Attachment A – New Public School in Mulgoa Rise, Glenmore Park – Response to additional agency comments

Agency and Issues	Response
Penrith City Council	
<p>The Department is urged to have strong regard to the need to ensure (in line with the Premiers Priorities and the Minister's recently issued Planning Principles), the need for high levels of canopy tree planting and green streets, Council raises that regard is to be had to Council's previous comments provided in cover letter dated 1 October 2021 including:</p>	
<p>(i) It is critical that planting within the front setback at this location is proposed where there are no street trees (also refer comments below in relation to street tree removal and recommended actions). The development of the site shall achieve and provide continuous canopy tree planting around the periphery of the development to screen the hard stand / manoeuvring area associated with the waste facilities.</p>	<p>The Landscape Design contained in Attachment D provides a continuous tree canopy has been provided to street frontages where possible. However, there is an opportunity to provide a staggered tree alignment to further increase the tree canopy and screenin

Drawing Title
PLANTING PALETTE

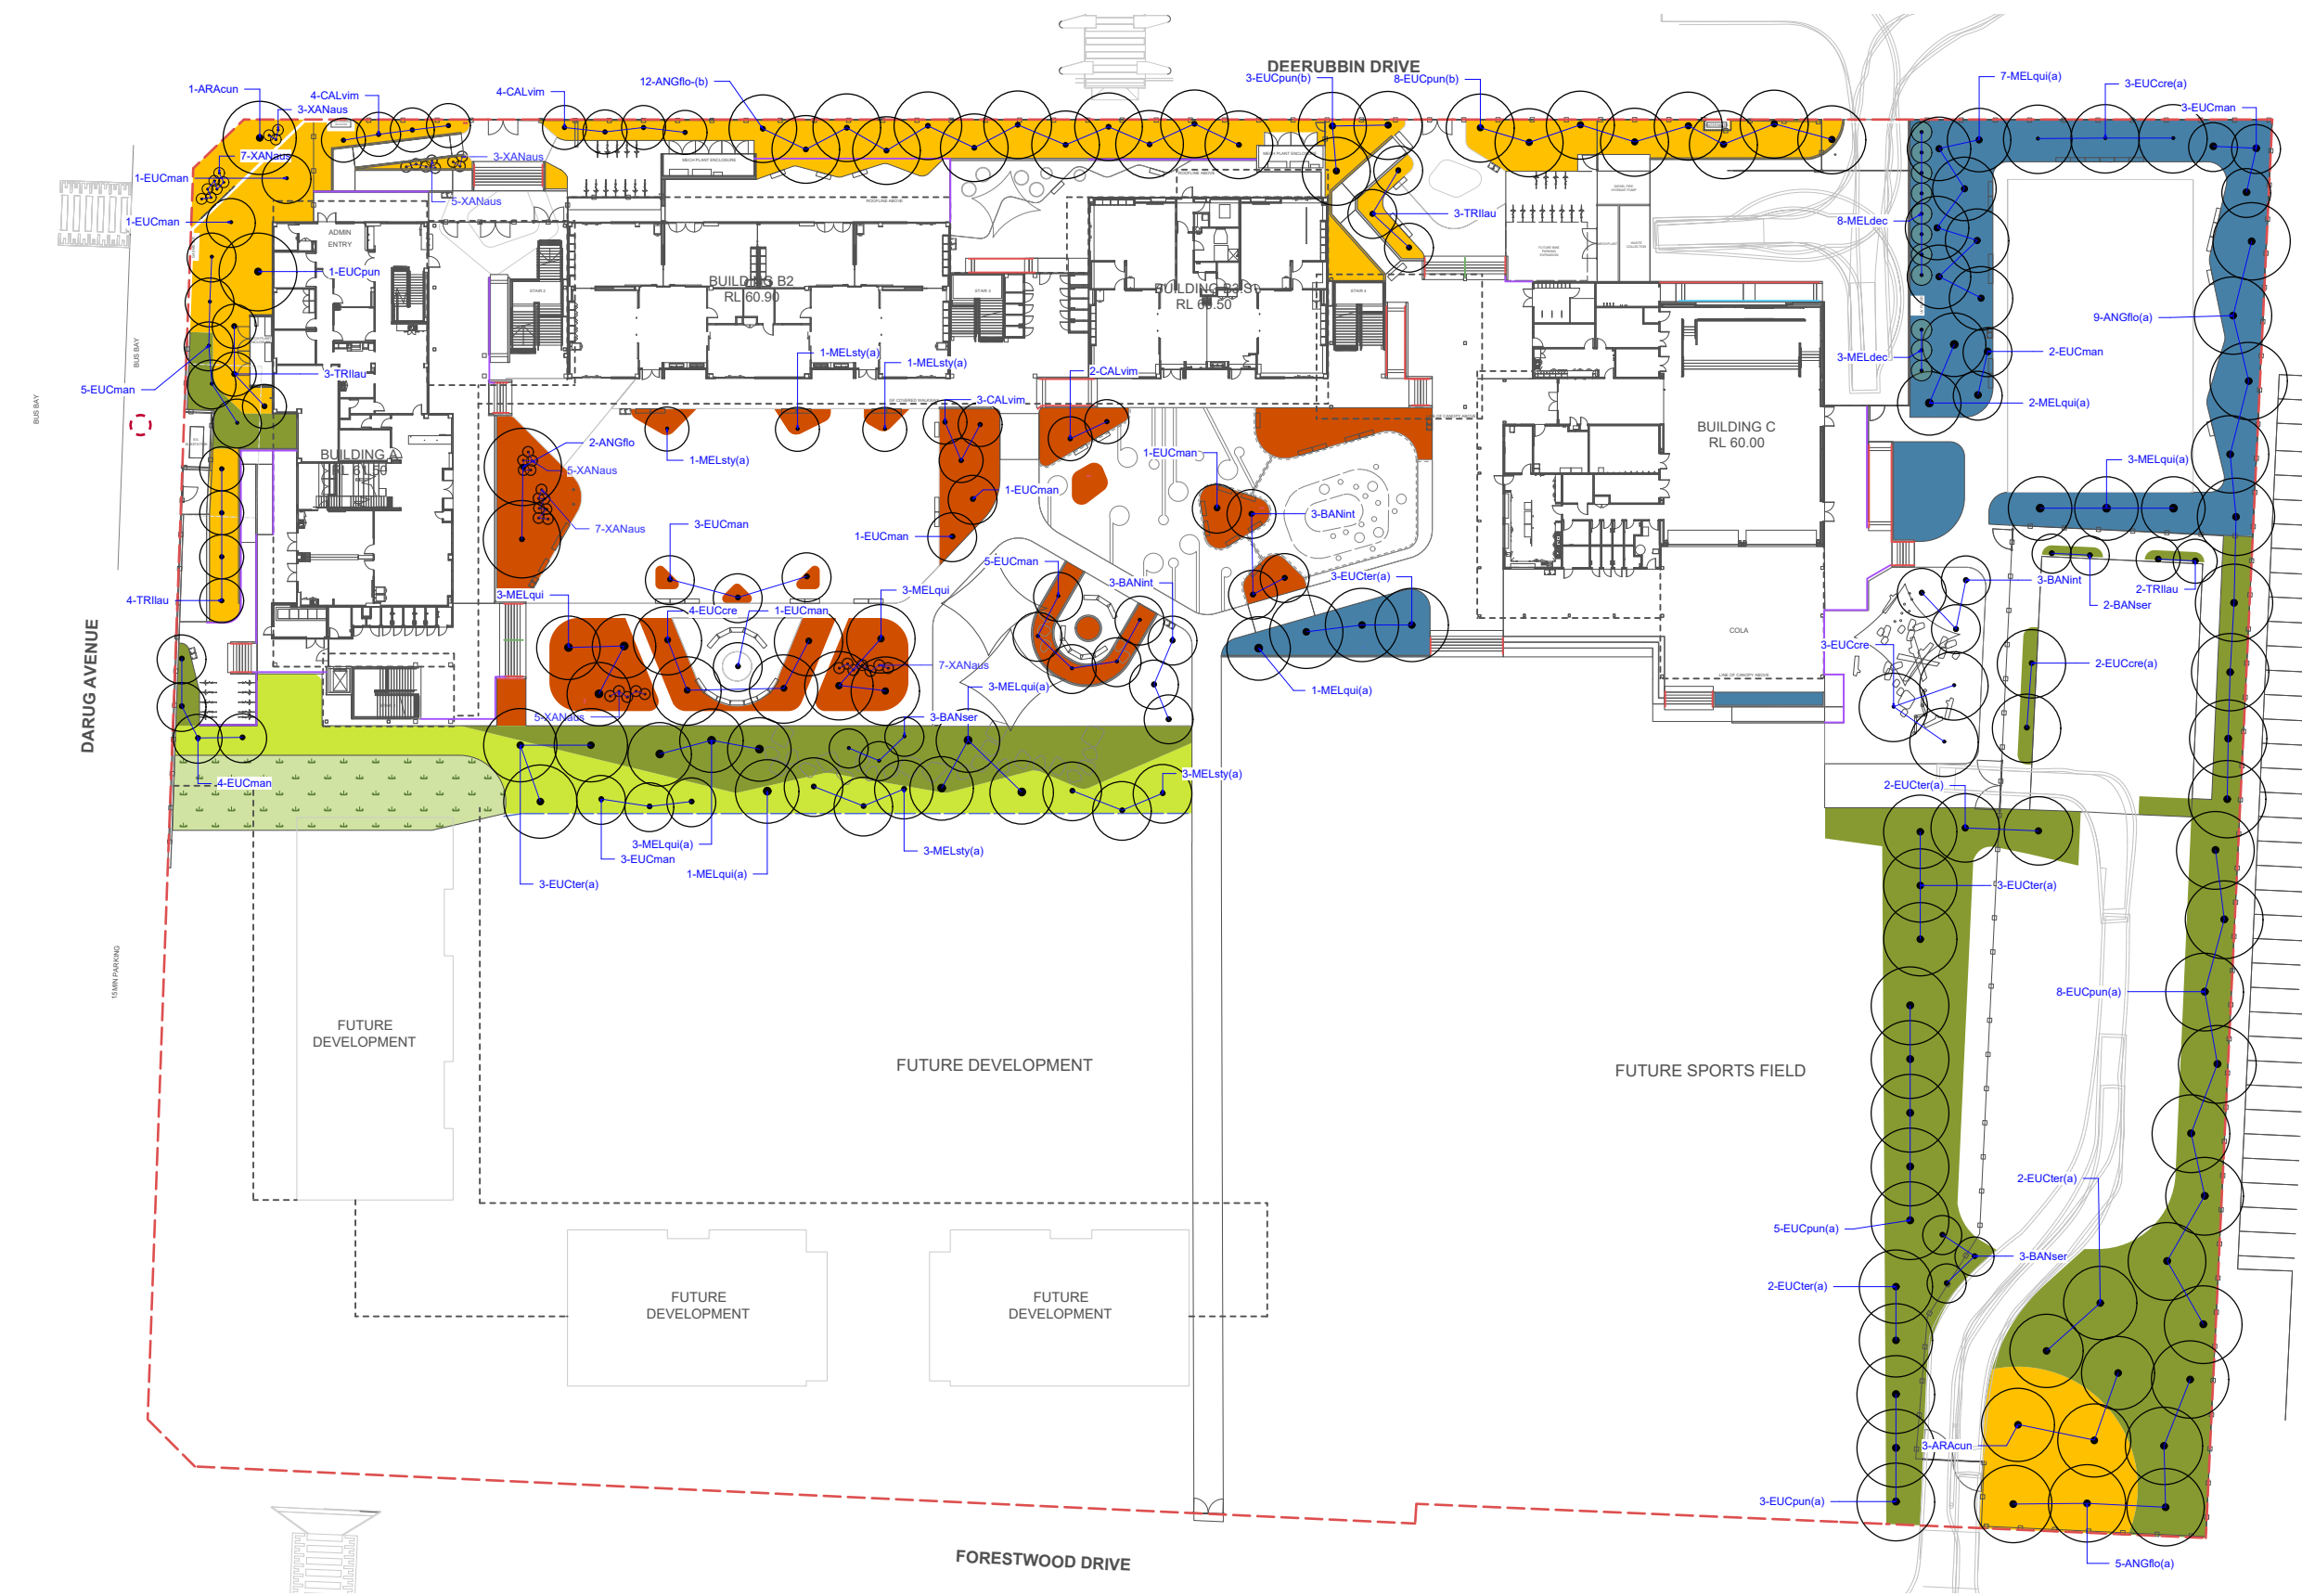
EES – Environment Energy and Science Group	
<p><u>Use of local native provenance species</u></p> <p>In its submission on the EIS, EES recommended the SSD uses a diversity of local provenance native species from the relevant native vegetation community (or communities) that once occurred on the site/locality, rather than use exotic species or non-local native species. EES recommended this particularly as the site is located near the Mulgoa Nature Reserve and Surveyors Creek Nature Reserve, both of which are mapped as containing biodiversity values. The EIS notes Mulgoa Nature Reserve contains good quality Cumberland Plain Woodland, which is listed as a critically endangered ecological community under the Biodiversity Conservation Act 2016 (BC Act), while Surveyor's Creek Reserve contains River Flat Eucalypt Forest, which is an endangered ecological community.</p> <p>EES also recommended in its submission on the EIS:</p> <ul style="list-style-type: none"> • The RtS and Landscape Design Report should identify the native vegetation community that once occurred on the site, or in the locality. • The Landscape Design Report should provide a list of local native species from the relevant vegetation community to be planted and demonstrate that the plant species to be used are of local provenance. • the Planting Palette and Planting Schedule in the Landscape Design Drawings are amended to use local native provenance species and 	<p>Noted.</p> <p>An updated planting schedule that identifies species from local plant communities is contained in the Updated Landscape Design Drawings – Attachment D.</p> <p>Planting palette images will be updated to reflect selected species. Exotic species have been removed from the design.</p>

Agency and Issues	Response
<p>identifies which species are local native provenance species and any non-local native or exotic species.</p>	
<p>In response, the RtS states “where possible species from the local plant communities have been included in the design (subject to availability & EFSG requirements). To supplement these species local natives or robust native species have been selected to suit the site conditions”. The RtS does not specifically identify which native vegetation community once occurred on the site, or in the locality and it is unclear why the local native species need to be supplemented by other ‘robust native species’.</p> <p>EES notes in the RtS that Council recommended alternative tree species be identified that are more consistent with Shale Plains woodland. It is noted the Planting Schedule in Appendix C identifies plant species that are from Cumberland Plain Shale Woodlands and the Shale-Gravel Transition Forest Community but the Planting Schedule also includes numerous species that are not identified from these communities.</p>	<p>An updated planting schedule will be included to provide information regarding local plant species / communities. Native species from local planting communities will be prioritised based on availability and suitability for the school environment. No objection to the inclusion of a condition to this effect, subject to review of draft conditions.</p>

<p>EES repeats its recommendation that a condition of consent is included for any planting / landscaping associated with the SSD to use a diversity of local provenance native trees, shrubs and groundcover species (rather than exotic species or non-local native species) from the relevant native vegetation community that once occurred in this locality (see below). EES recommends an appropriately qualified bush regenerator is engaged by the proponent to provide advice on appropriate local native species that can be used on the site and to revise the Planting Schedule.</p>	<p>Noted. Landscape documentation will be peer reviewed by a Bush Regenerator Consultant who will provide a compliance statement of the final documentation.</p>
<p>Installation of Habitat Features</p> <p>EES recommended the school installs habitat features such as logs, a range of artificial nest boxes which are suitable for native fauna likely to utilise the site such as mobile birds and bats and bee hotels. The RtS notes reclaimed logs, boulders and the use of native trees have been included to provide habitable spaces, and that other habitat features will be considered where appropriate.</p> <p>EES recommends the installation of habitat features on the site is included as a condition of consent.</p>	<p>Habitat elements will be included and integrated into the landscape design. As no significant existing trees occur on site mobile bird and bat accommodation is not achievable (until trees mature). As such priority will be placed upon bug hotels, logs and boulders. SI NSW will accept the inclusion of a condition requiring priority on bug hotels, logs and boulders, subject to a review of the draft condition.</p>
